CITY OF PORTLAND BUILDING PERMIT

Located At 62 WESTMINSTER AVE

Job ID: 2011-10-2356-ALTR

2012-14371 AMEND

**S3**

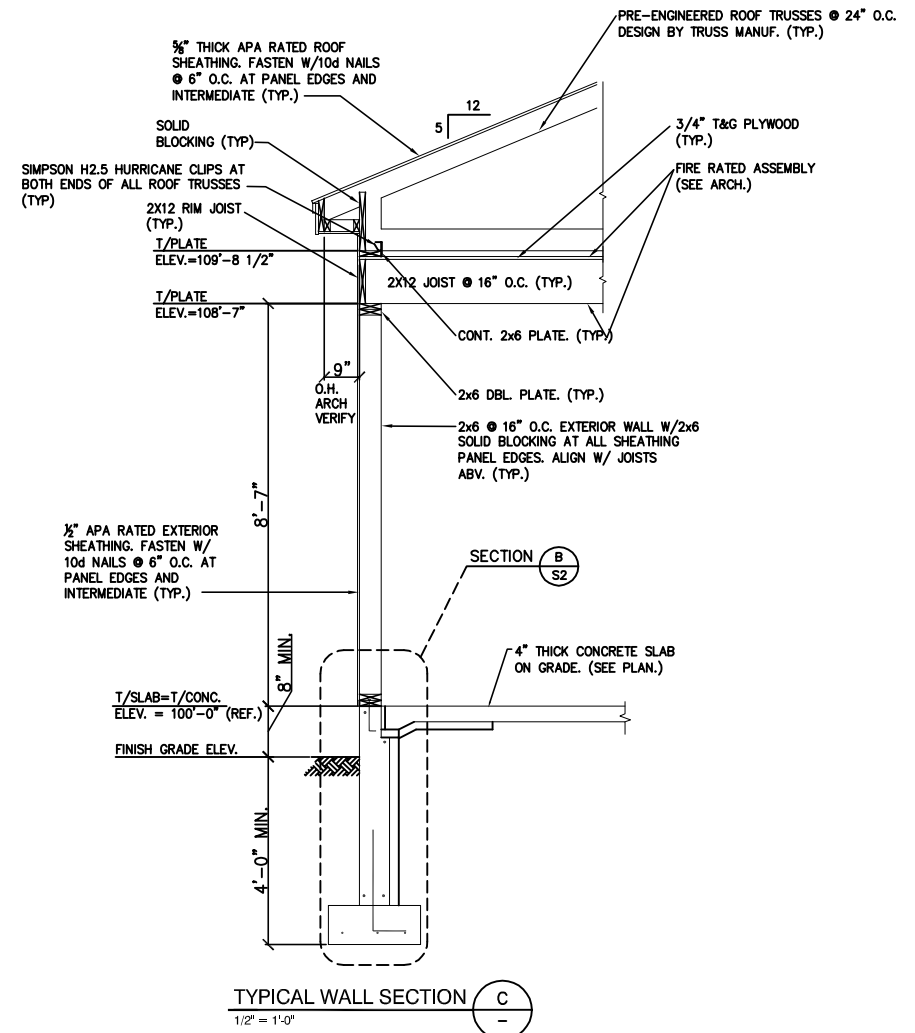
The header in the schedule (8'-7" to 10'-6" maximum rough opening) is designed for the future expansion (two stories) which includes the weight of the second floor as well as the roof on the header above the bay window. The header required for the two story application is a 5 1/4" x 11 7/8" LVL as stated in the schedule with 3-2x6 jack studs. However, with the single story condition with roof load only on the header (plus the additional dead weight of the second floor joists that are installed) and the rough opening only 9'-0" (please verify) the header is more lightly loaded and only requires a single 2x6 jack stud (marginal).

I assume the appropriate 5 1/4" x 11 7/8" LVL header was installed above the opening. Hence, when the future expansion is implemented (i.e. two stories), the single jack stud will be inadequate to support the intended load. To remedy this issue during the proposed future expansion, an additional header will have to be installed in the second floor wall directly above the first floor header to remove the weight of the roof from the first floor header and the jack studs for the second floor header will have to align with the king studs at both ends of the header on the first floor. This does not mean that a window will have to be installed, only that the second floor wall shall be framed in this manner.

Yesterday we had a framing inspection and he noted some differences in the plans and the actual. The only one that is really significant, (not an easy fix) is the header and structure around the 3 bay window in the salon. The header schedule calls for 3 kings and 3 jacks and they only did one jack. The inspector noted that it might be possible for the architect to come up with some type of hanger that would eliminate the need to tear it apart and redo it.

There are concealed flange beam hangers that could have been installed prior to the header installation. Yet that is not a good solution now as it would require the removal of the header to install. In addition, there are "header hangers" that could be installed now without removing the header yet they do not have nearly the capacity required.
